Supplementary Plan pls. upload.

WA/7/19/RES - Lanes End, West Walberton Lane - Additional information request

PLOT 3 FLOOR PLANS AND ELEVATIONS

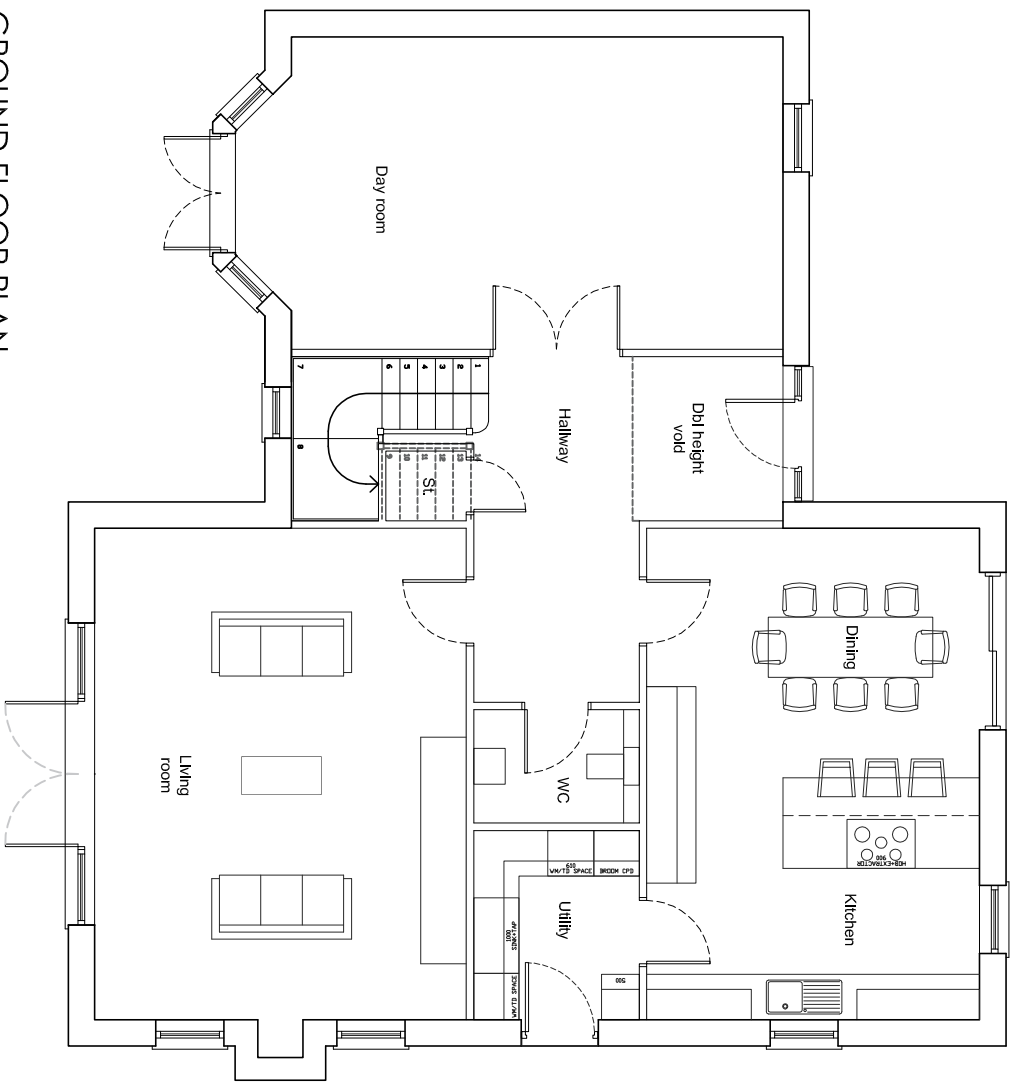
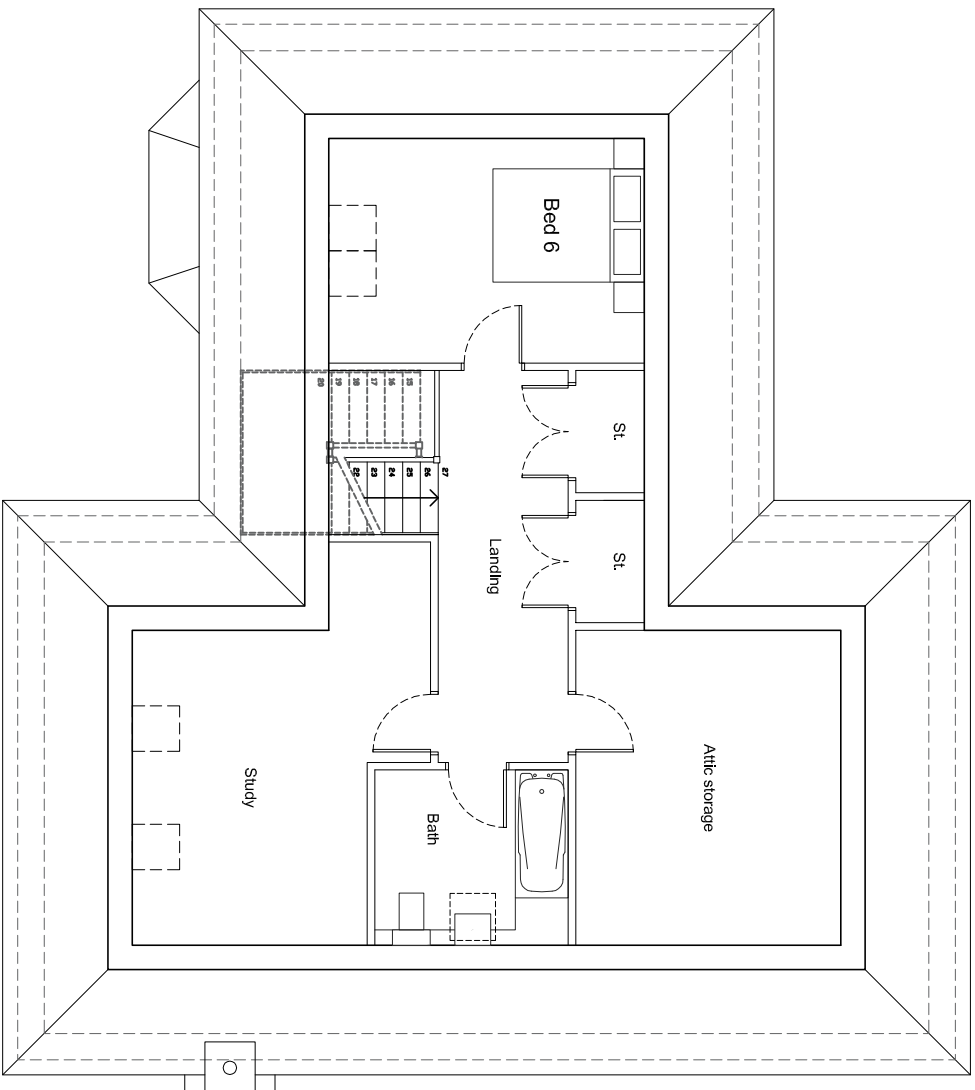
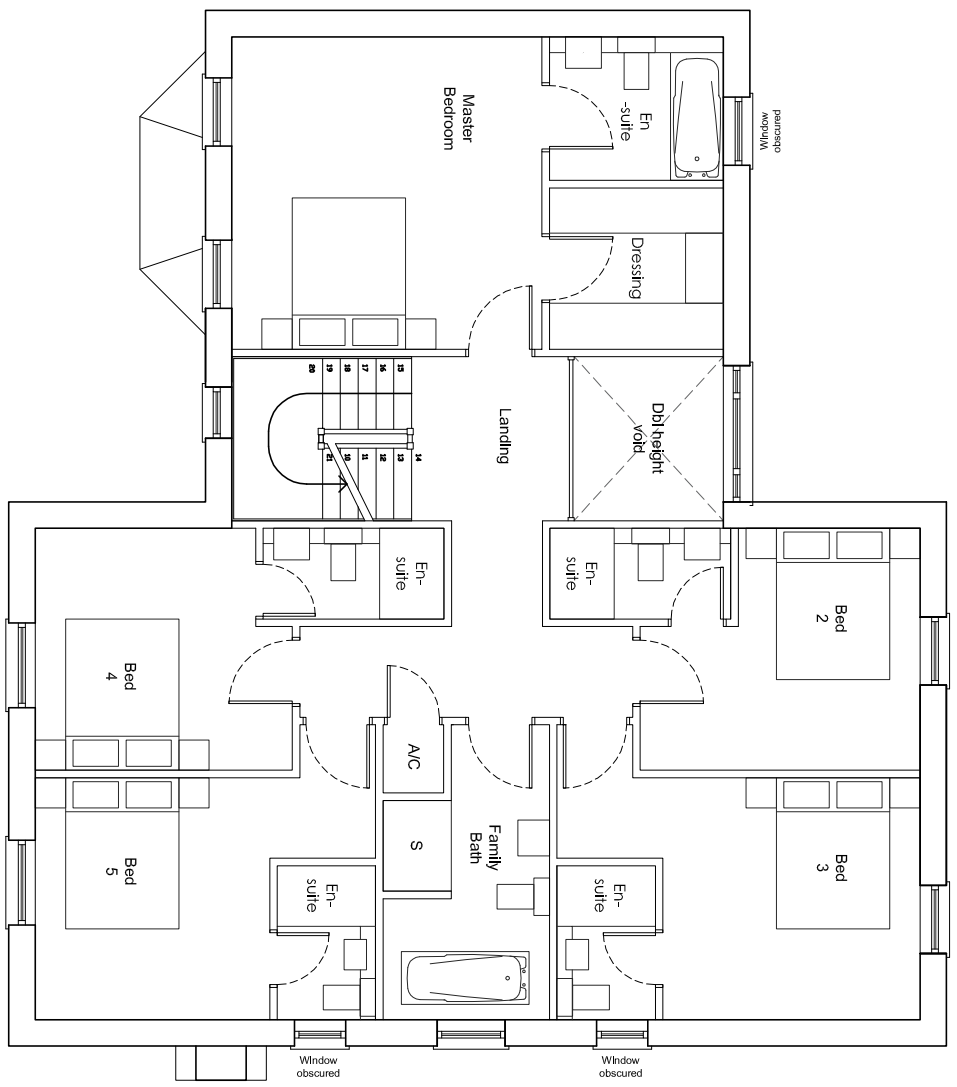
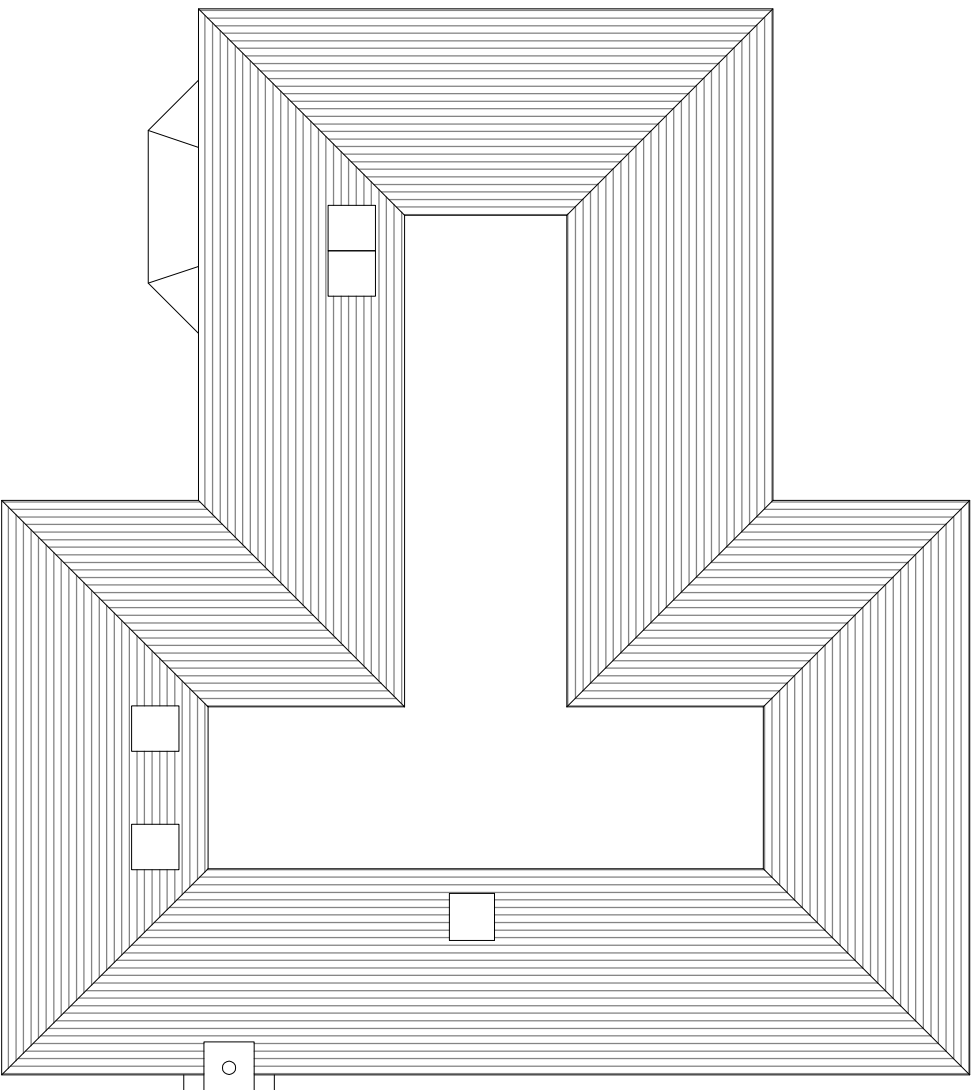
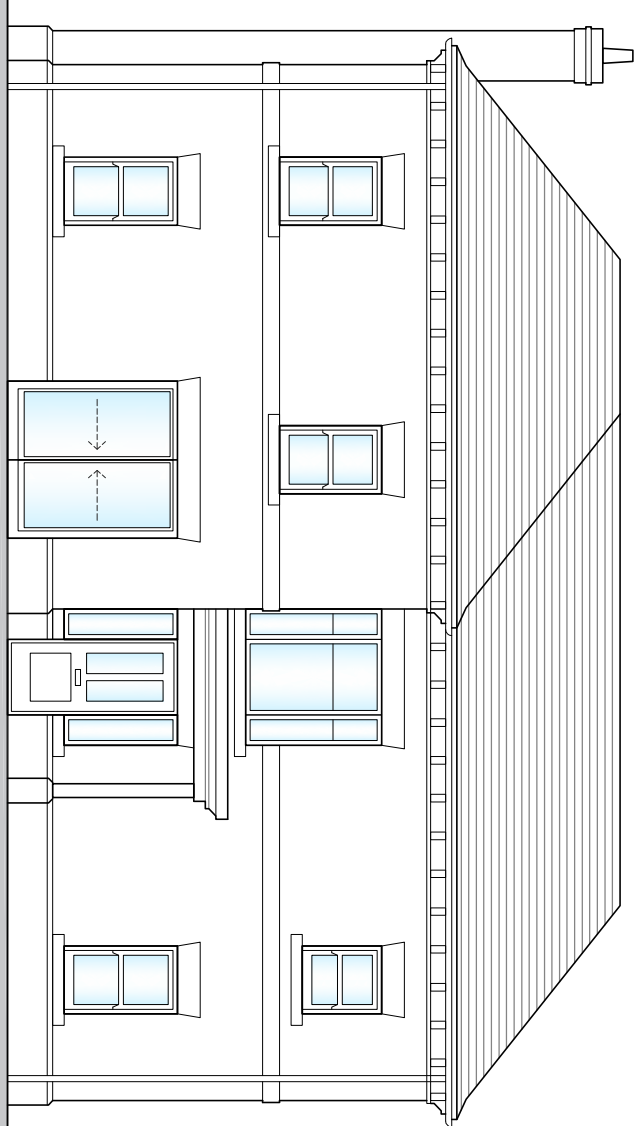
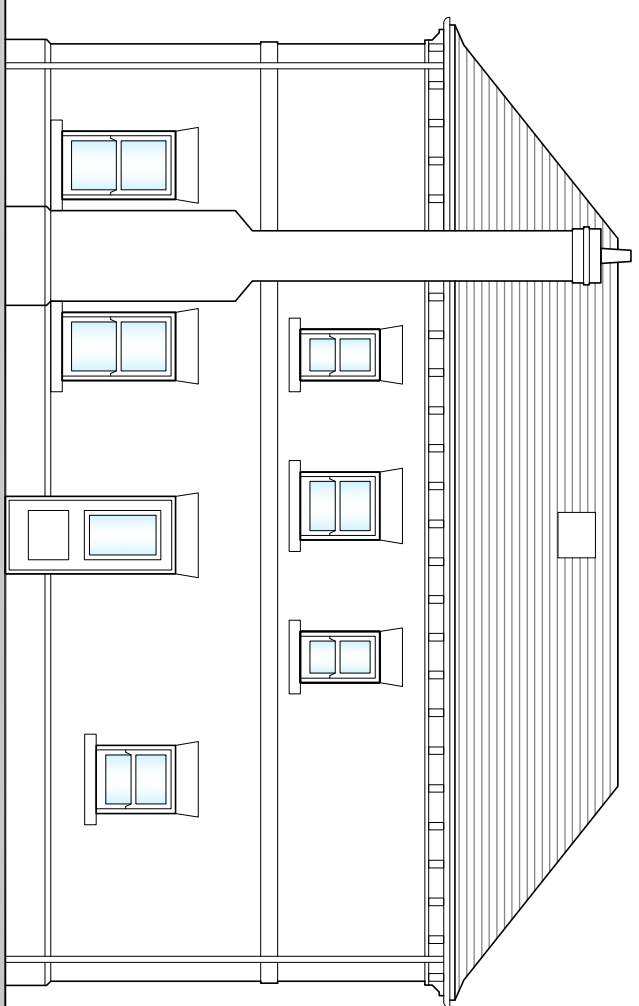
1. Amend the layout to ensure that a minimum of 9 metres exists on from blank gable end (or obscure glazed windows non opening below 1.7 metres in height) of nearest proposed house to gable end of 'Woodlands' which currently incorporates sole habitable room windows.
2. Remove second storey of houses/rooms in roof. 3 storey townhouses would not be acceptable in this location

2, we fail to see the merit in removing the room in the roof, this would have no impact on the height of the buildings and would result in empty lift spaces which would not allow for good use of space as per the NPPF. You will note from drawing 19-001-PL-03 all the dormers on houses 3-6 are in the south and therefore can not be seen from the front or any point outside the properties. Currently prosperities one and two have the dormers on the north but I would be happy to move these to the south so these are the same and none can be seen from Arundel road. I also would like to mention the design of white cottage next door that will have dormers in the roof and Richmond house which has velum windows in the roof. As previously mentioned the new ridge heights will be lower than the current house at Lanes end this can be seen in the scale drawings provided. If you could let me know if this is acceptable as if possible to avoid I would prefer not to have to appeal the reserved matters for this small item.
